# Sea Link

Document 7.4.10: Draft Statement of Common Ground Between National Grid Electricity Transmission and the Maritime and Coastguard Agency.

Planning Inspectorate Reference: EN020026

Version: D  
March 2026

Plate 2.1 Stakeholder areas of interest with regard to under-keel clearance

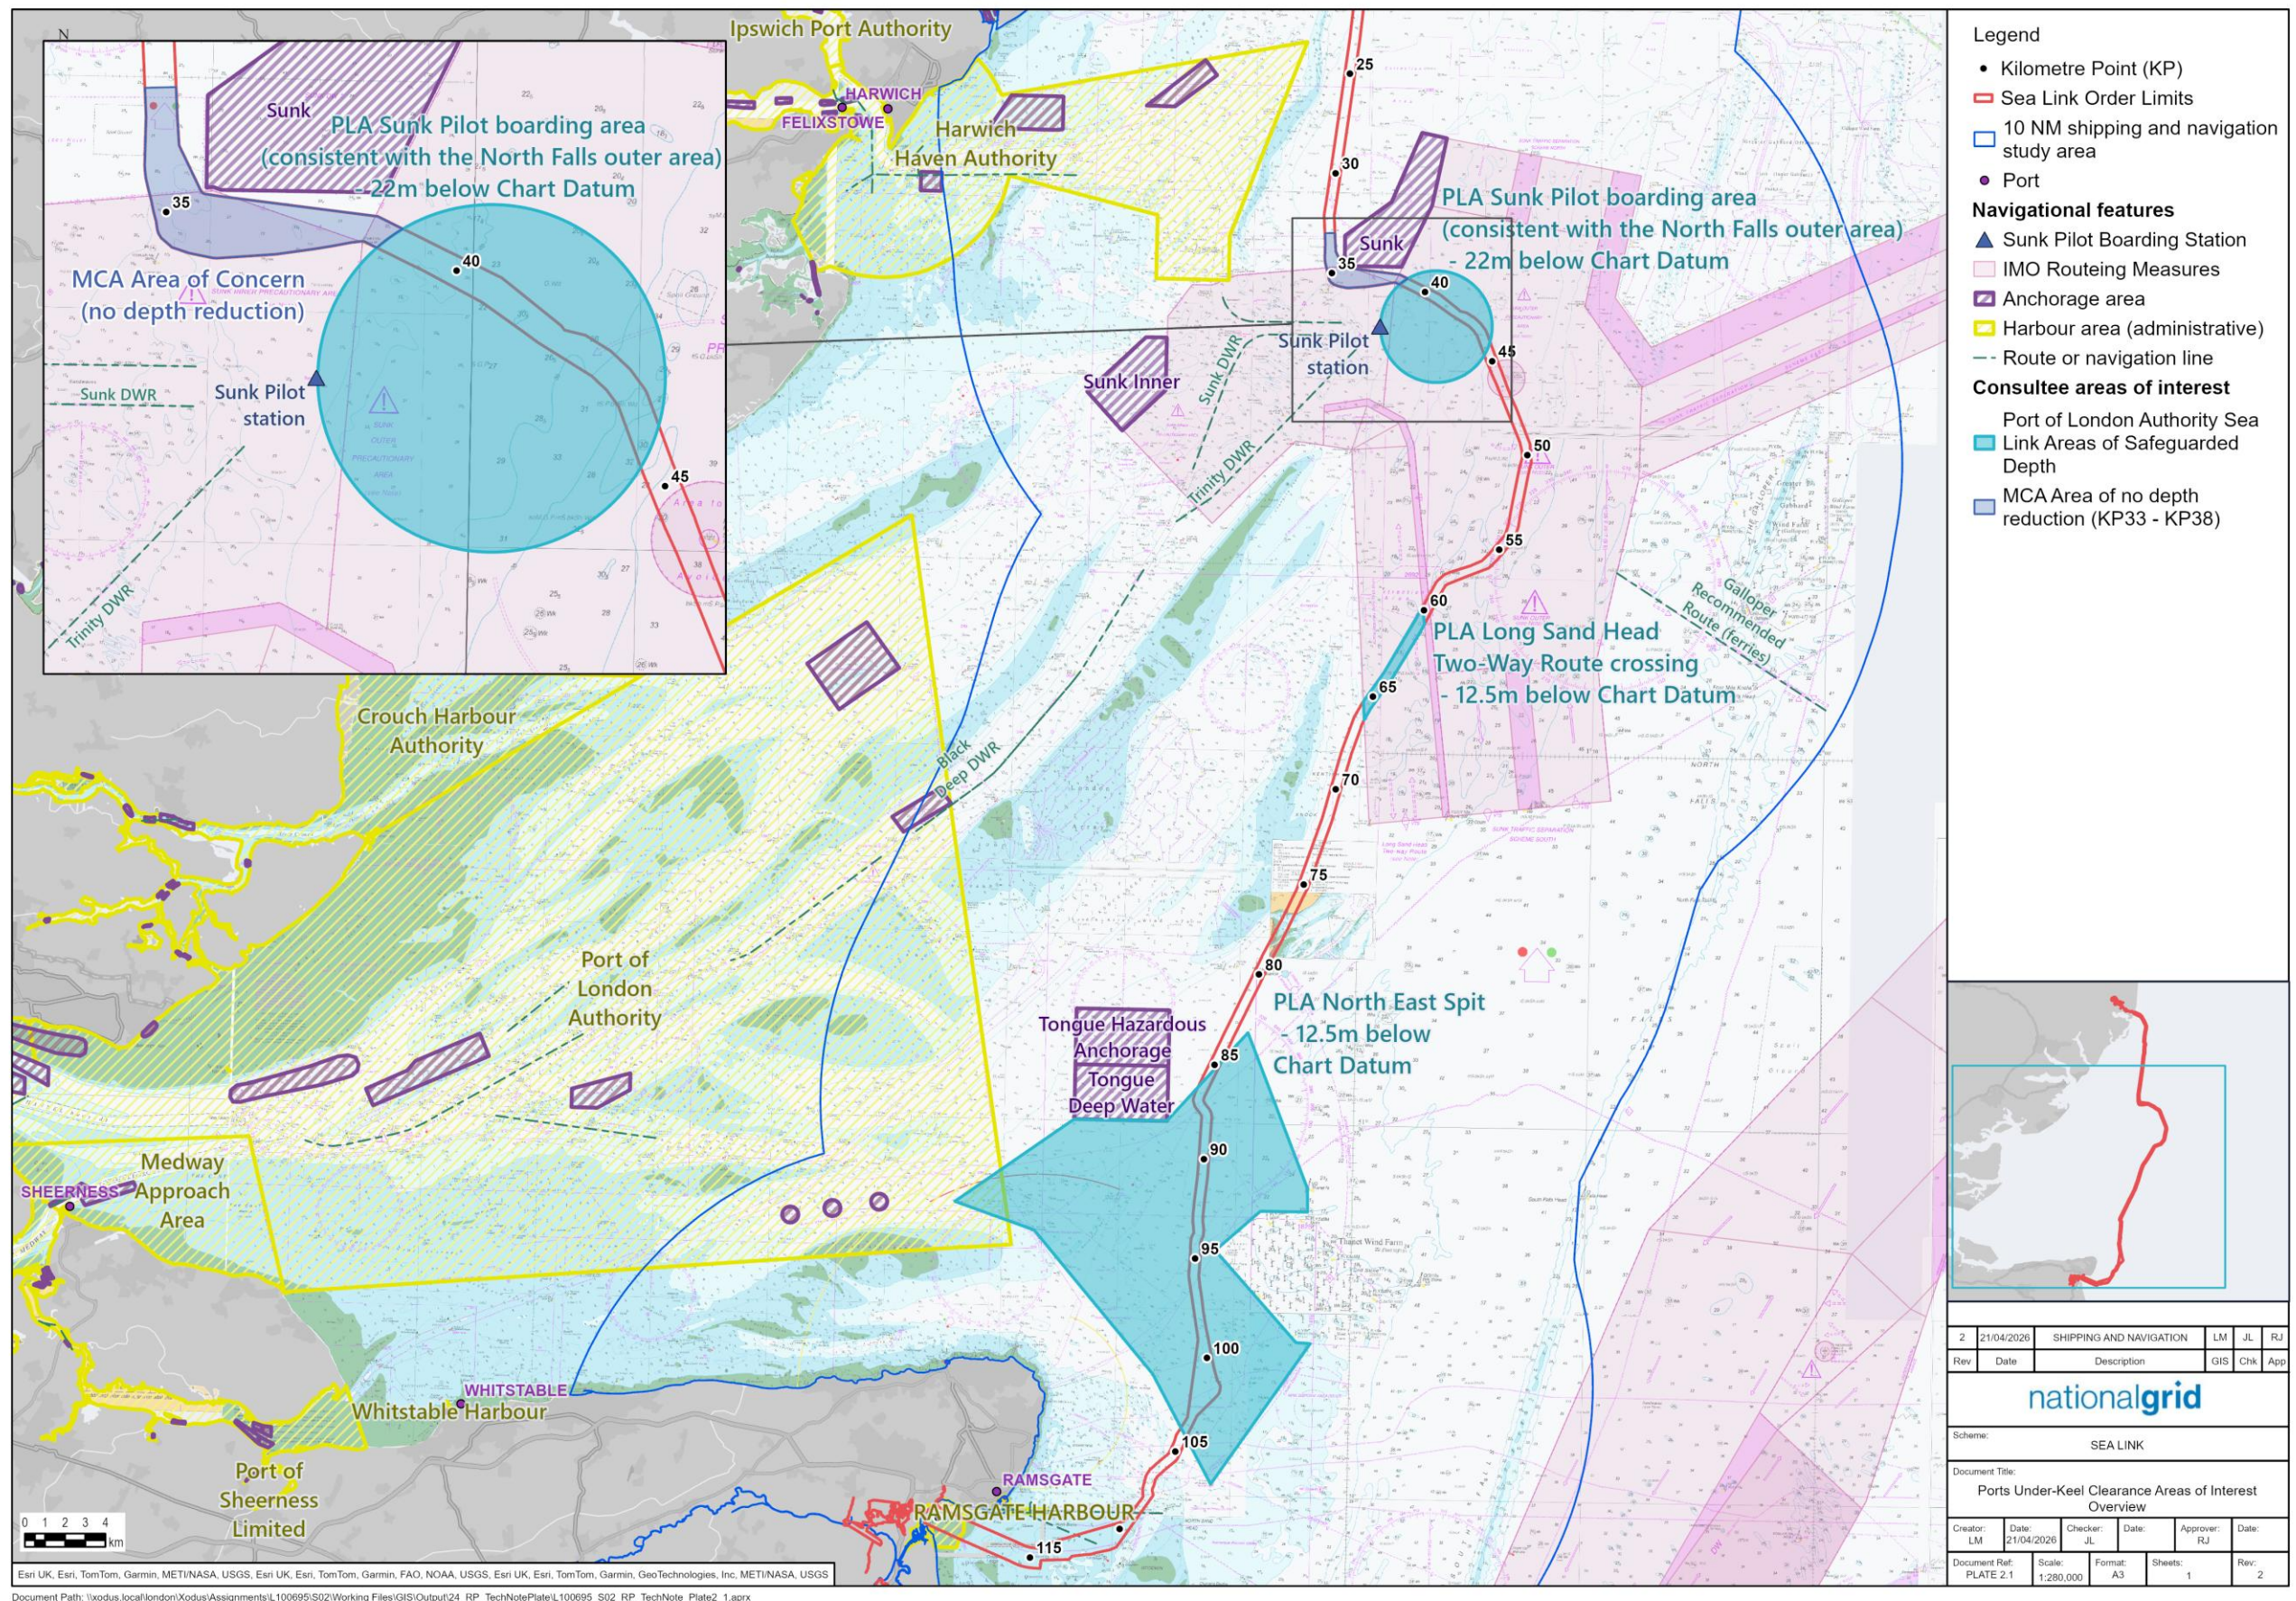
Ref	Relevant Application Document	Summary of Description of Matter	MCA Current Position	The Applicant's Current Position	Status
			<p>The MCA has clarified this to the project team on 2<sup>nd</sup> March that at KP 33-38 there should be no depth reduction as per CBRA due to the proximity of the Deep Water anchorage, and at KP38-KP44 the ports' 22m requirement applies. The 5% applies to the whole cable route outside of any agreed safe guarded depths, whichever provides maximum depth. There is no conflict therefore with the port's requirements.</p>	<p>agreement. The Applicant discussed this matter at a meeting with the MCA arranged on 16 January 2026.</p> <p>The Applicant confirms that following the meeting on the 16 January 2026, clarity was provided from the MCA with regards to their Areas of Interest. The Consultee would like the 5% maximum depth reduction to apply outside of the port's 22m safeguarded depth at the Sunk. The Applicant confirms that this is currently secured as Condition 4(6) within the Deemed Marine Licence and is applicable to the whole Offshore Scheme and not just the Areas of Interest identified by the MCA.</p> <p>Further to the above, the Applicant confirms that an update to <b>Application Document 9.12 (B) Outline Navigation and Installation Plan was submitted at Deadline 4 [REP4-076]</b> in consideration of the MCA's feedback and is secured within the Deemed Marine Licence (DML) under Condition 4.</p> <p>The Applicant takes the view that the Proposed Project's Outline Navigation and Installation Plan is the appropriate place to secure the matter of concurrent Restricted in Ability to Manoeuvre (RAM) operations, and this aligns with the approach taken in the Five Estuaries and North Falls DCO applications, as they secure this matter within their NIPs.</p> <p>The Proposed Project's Outline Navigation and Installation Plan contains a figure which shows the Sea Link "Concurrent RAM Activity Area" (Plate 3.1) which has been agreed with Port of London Authority (PLA) Harwich Haven (HHA) and the Sunk VTS / Maritime Coastguard Agency (MCA), Trinity House, Five Estuaries and North Falls during a face to face workshop led by Five Estuaries on 14 June 2024.</p> <p>This agreed area also aligns with the Concurrent RAM Activity Areas defined within the Five Estuaries and North Falls NIPs. The Applicant has identified these two developments as the two developments which have the possibility of their construction programmes overlapping temporally with the Sea Link construction programme. The Applicant is concerned that a deviation from this previously agreed area between parties would leave them liable to breaching DML conditions if other parties were not held to the same area restrictions.</p> <p>The Applicant had established in discussion with Harwich Haven Authority and Port of London Authority that the Proposed Project should align with the Five Estuaries and North Falls projects' "Concurrent RAM Activity Area" which is shown in each of their NIP respective documents.</p>
